28 January 2025

Moriah College Redevelopment – modification 1 (SSD-10352-MOD-1)

Figure 10 Proposed eastern elevation

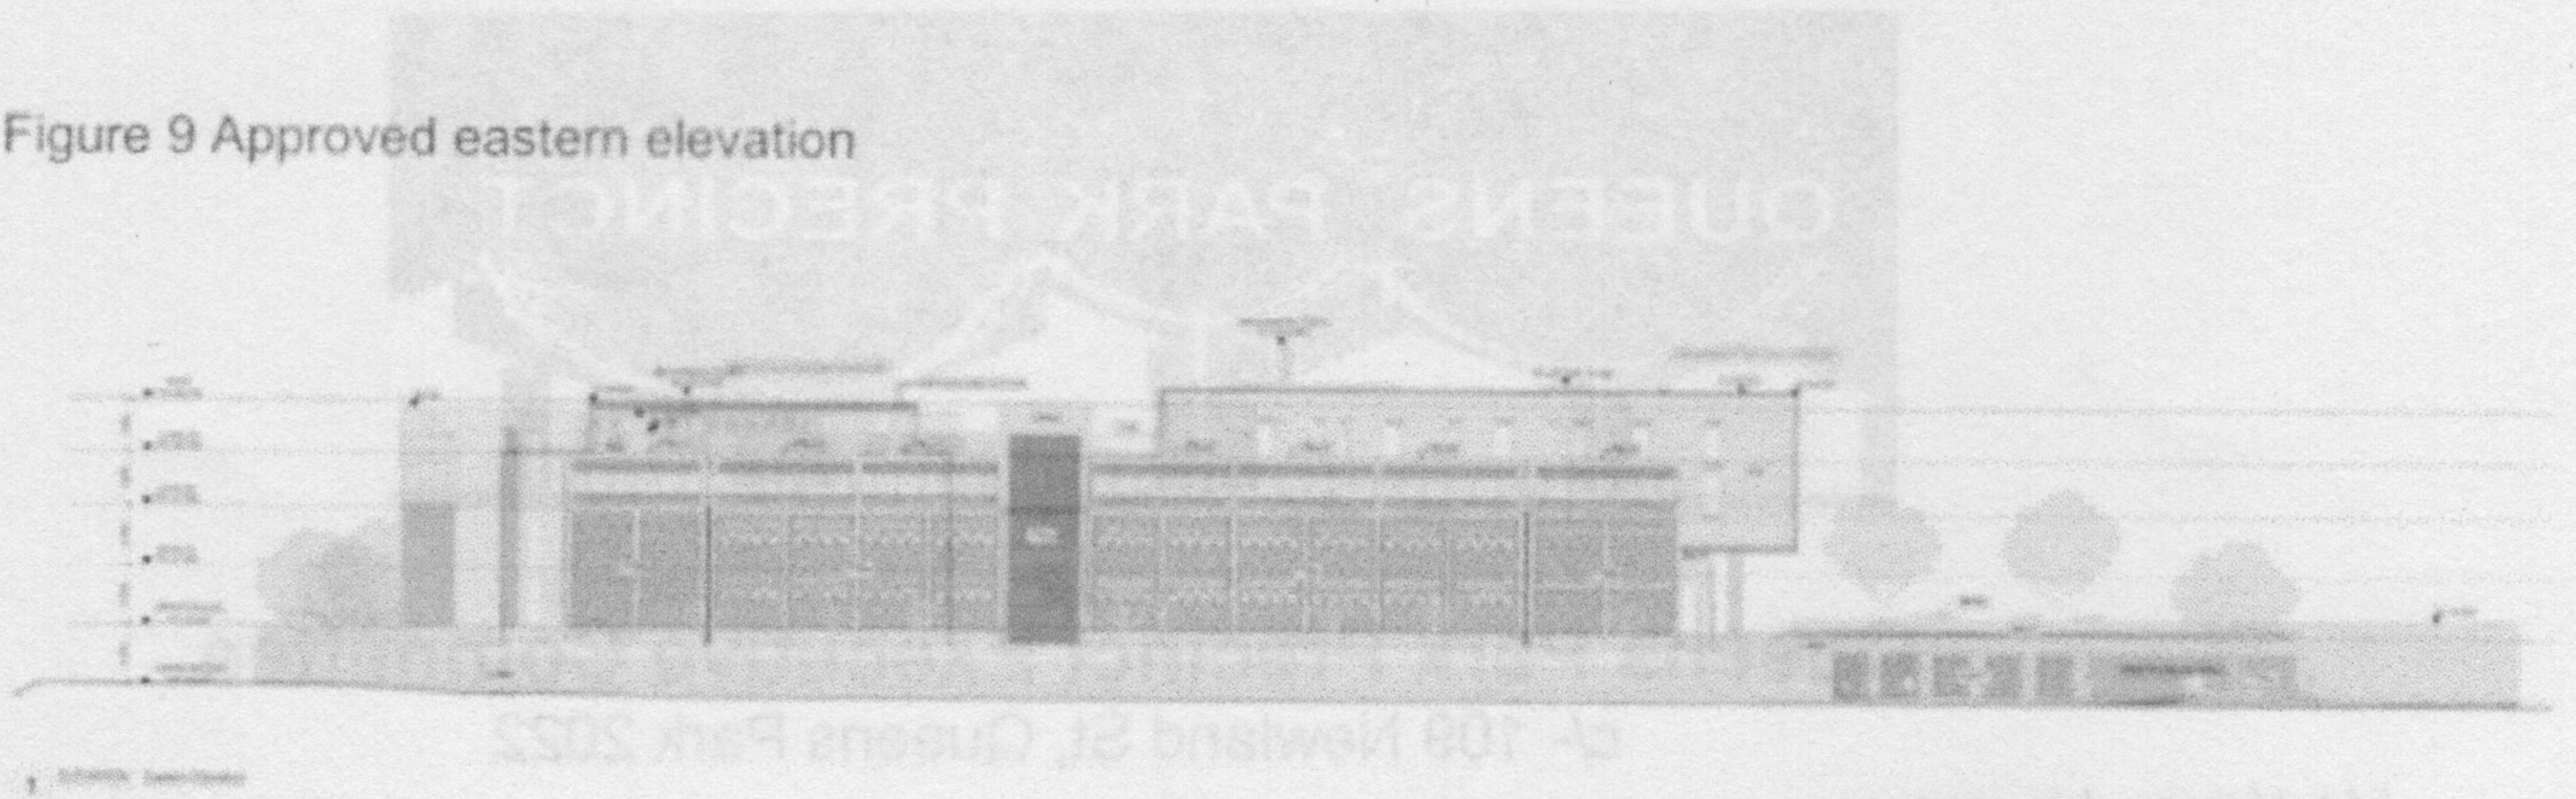
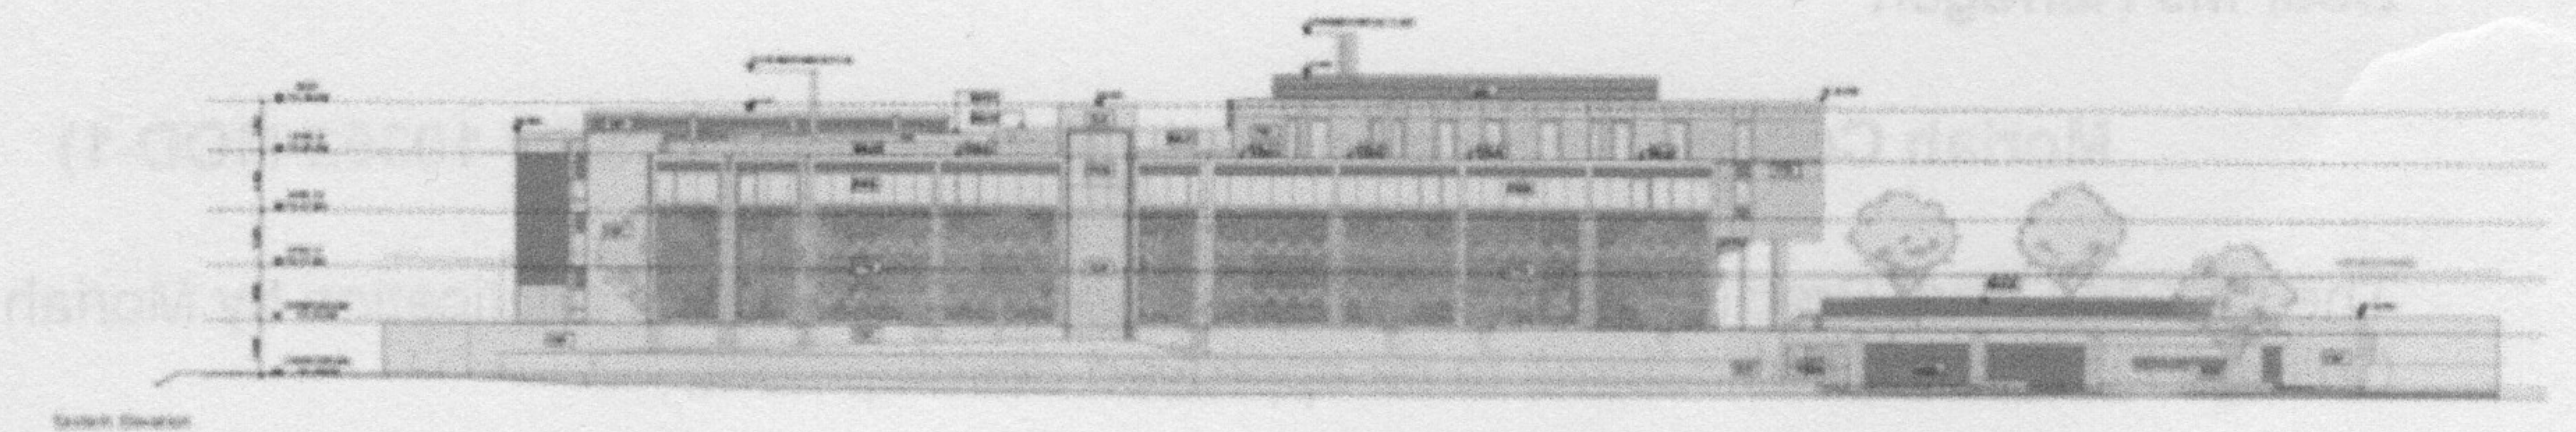
Now the modification proposal is to increase the height of the major building along Baronga Ave by 1.2m and extend the southern footprint of the building on the corner with York Rd.

While these modifications might sound modest, their impact on an already massive structure will mar the view from Queens Park even further, especially with the removal of trees that has been approved.

We believe that these increases should not be approved and the need for them incorporated into the existing approved footprint and height.
